Emailed April 28, 2021
DRB Comments for Meeting on 5/5/2021

From: Nicole M. Friedt, P.E., Development Review Engineer
AMAFCA

RE: DRB COMMENTS for PR-20201-004747

TRACT 2 PLAT OF TRACTS 1 THRU 12, AVALON SUBDIVISION UNIT 5:

Preliminary Plat
 for
Tracts 2-A and 2-B
 Avalon Subdivision Unit 5
 Being Comprised of
 Tract 2
 Avalon Subdivision Unit 5
 City of Albuquerque
 Bernalillo County, New Mexico
 May 2021

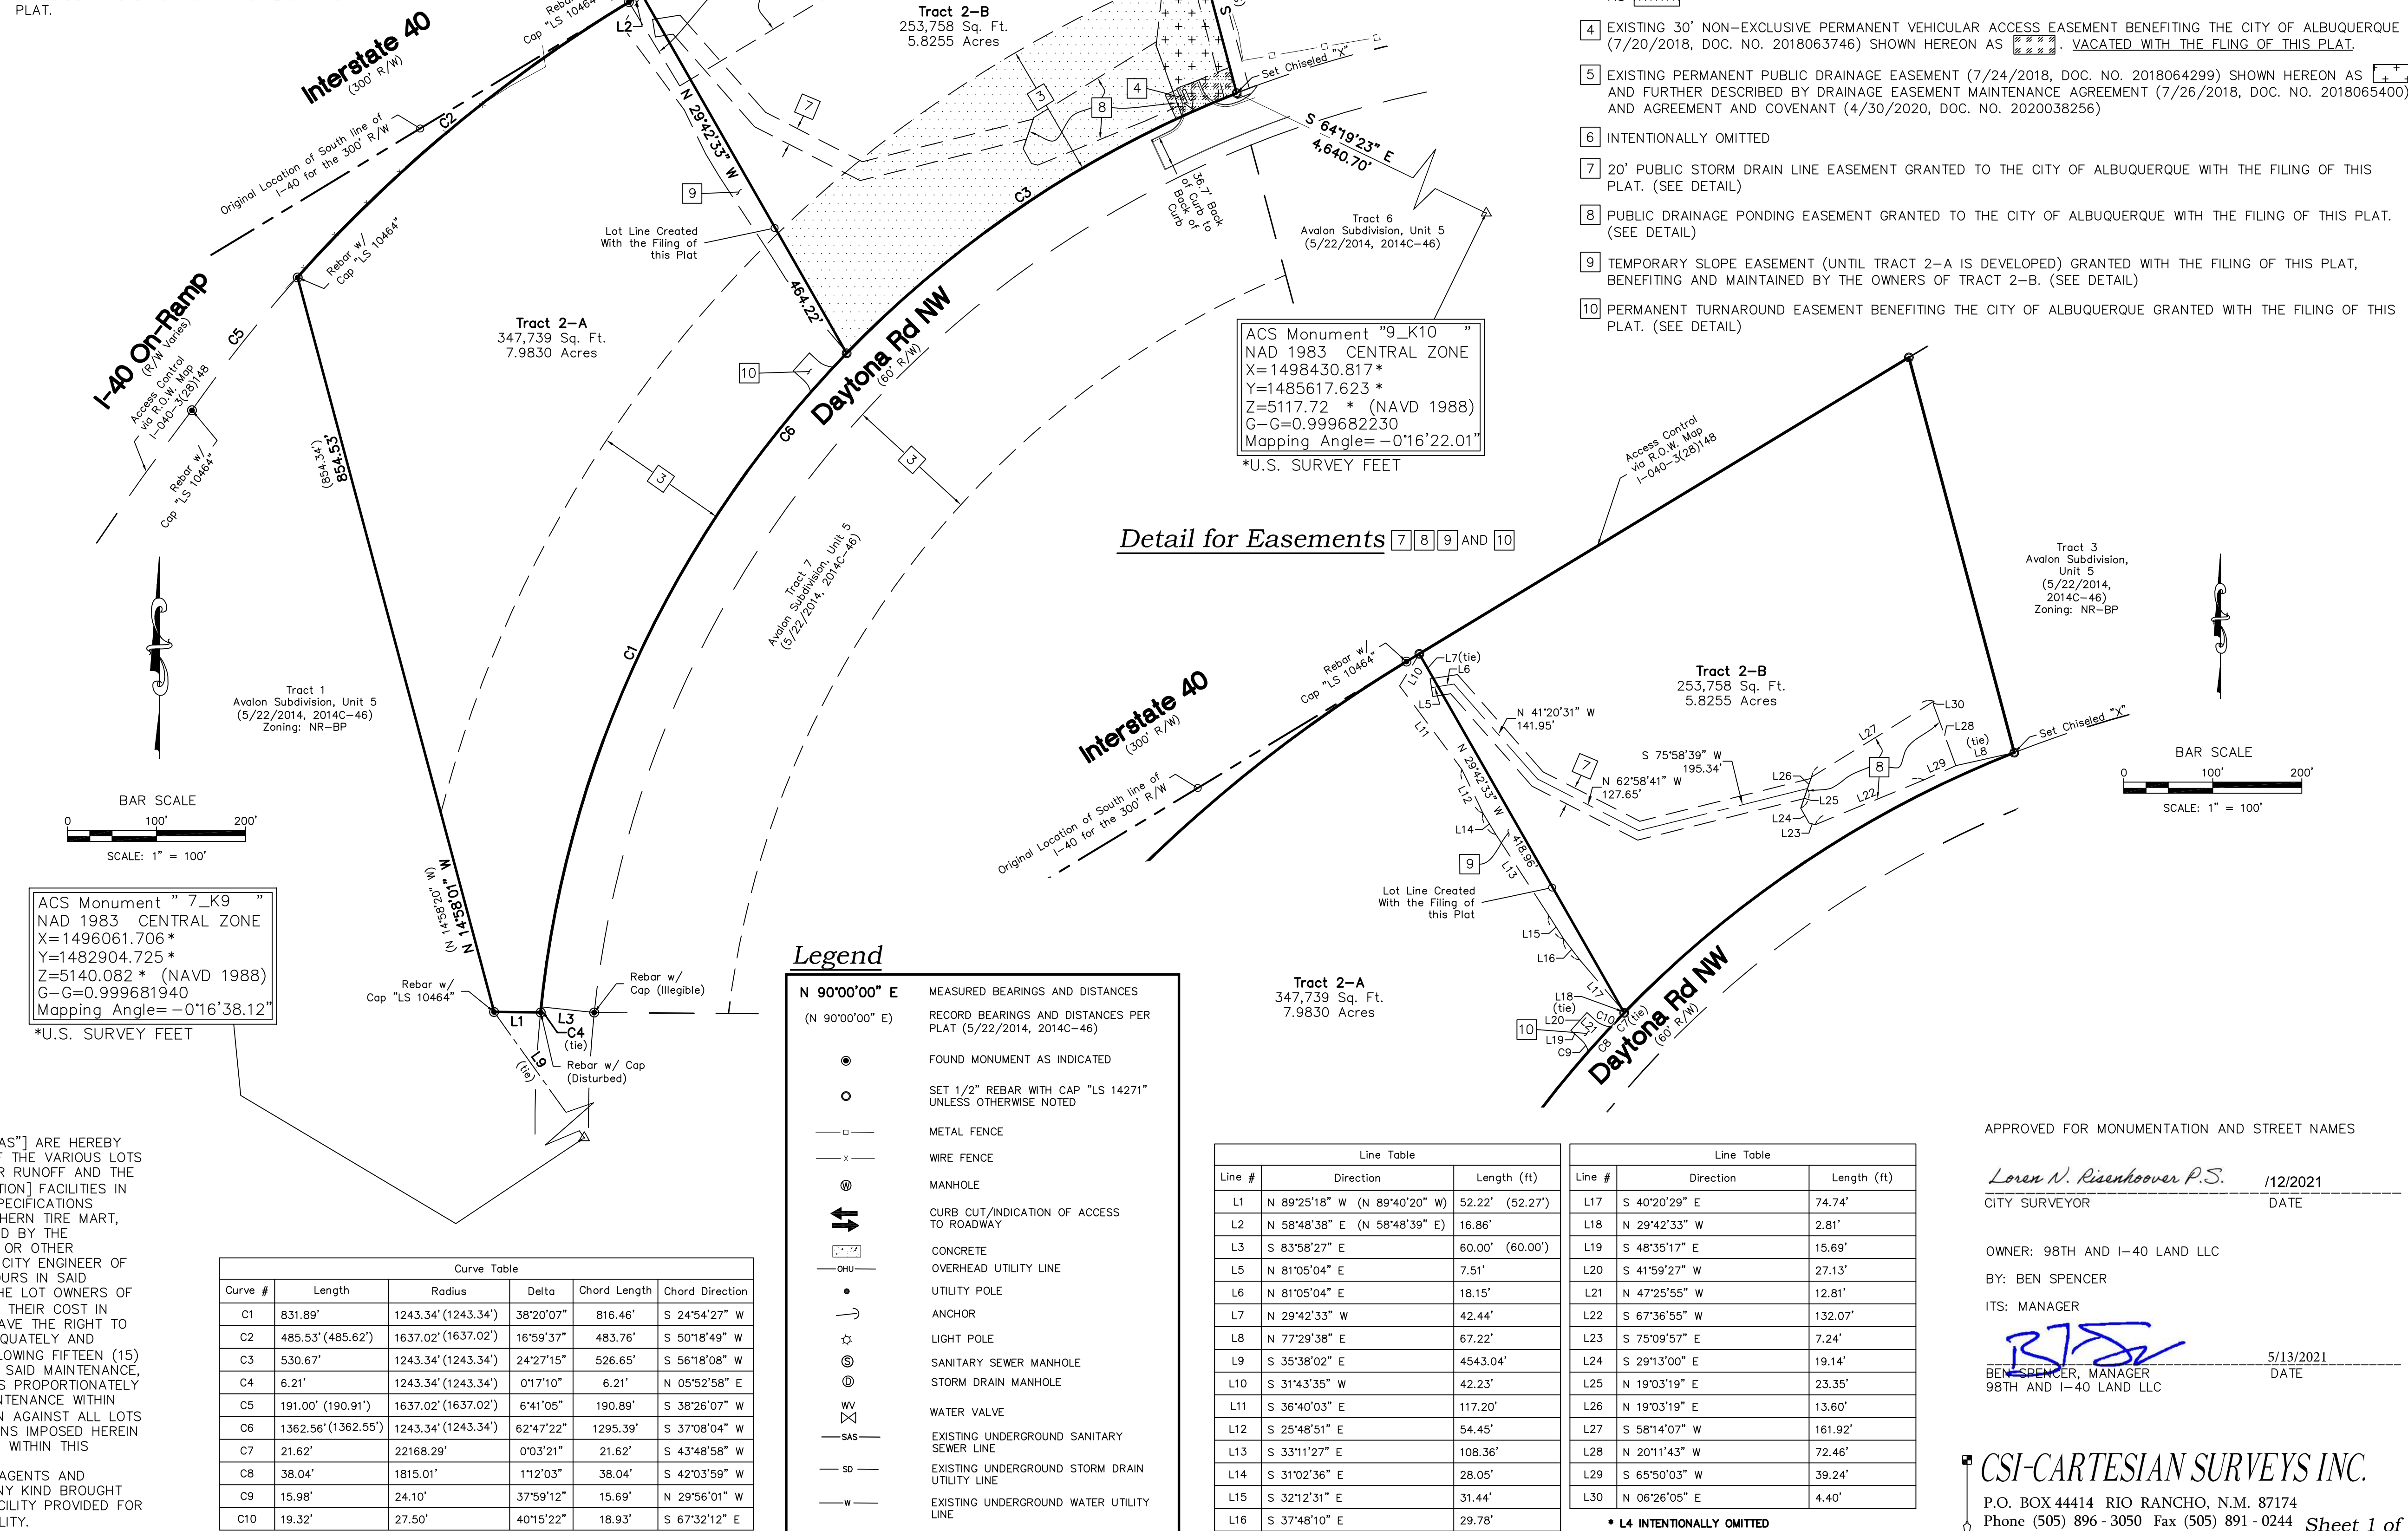
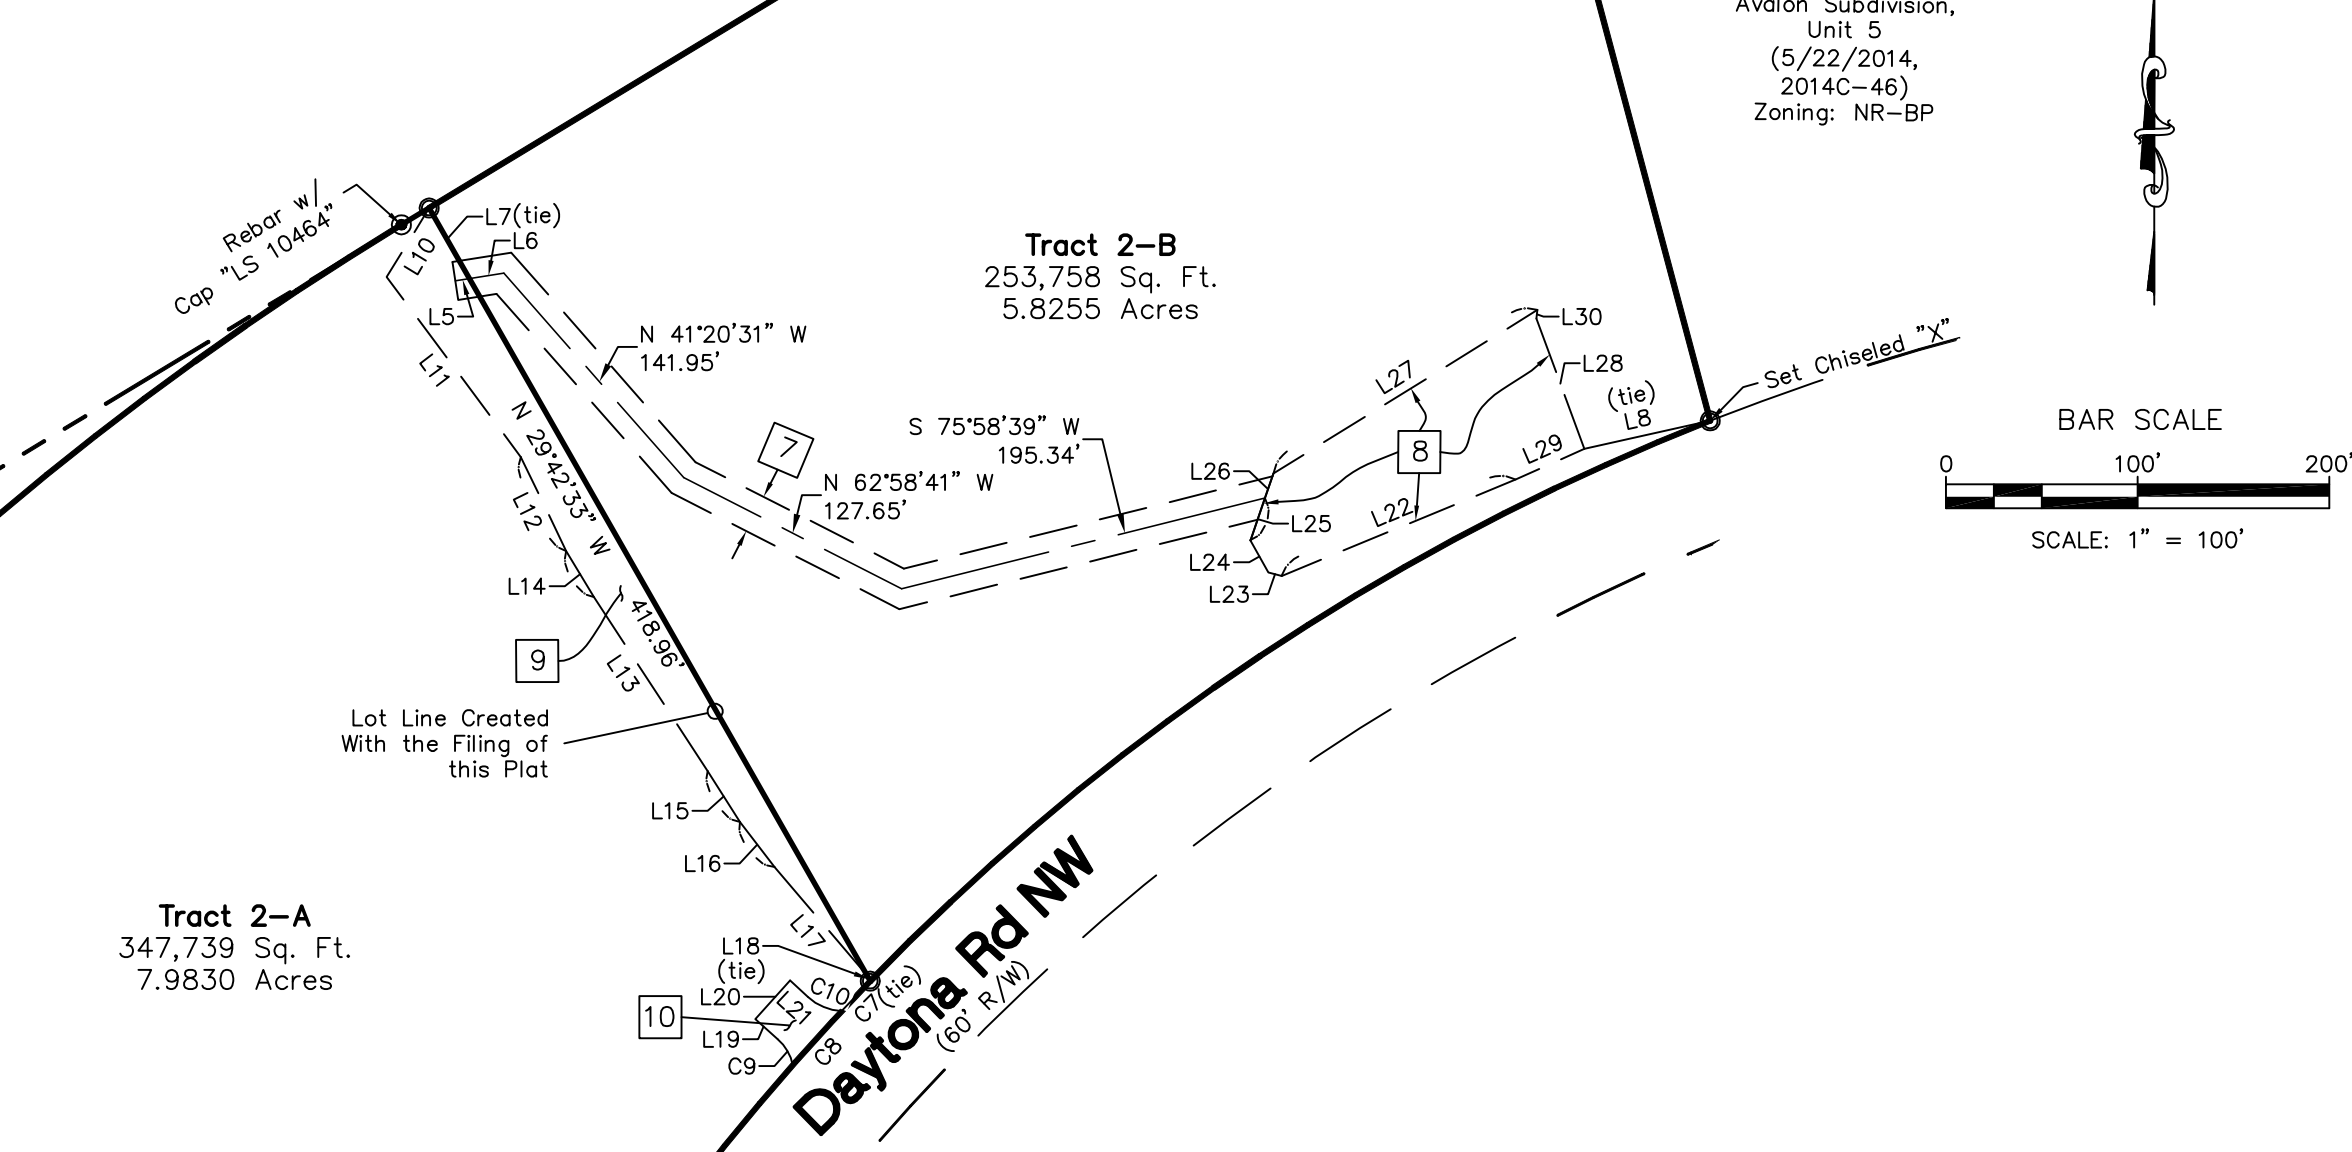
Plat | <ul style="list-style-type: none">• To whom is the drainage easement being granted (Note 7 on plat)?• Does there need to be a slope easement on lot 2-A for the benefit of lot 2-B? It is hard to tell where the toe of slopes fall in relations to lot lines. |
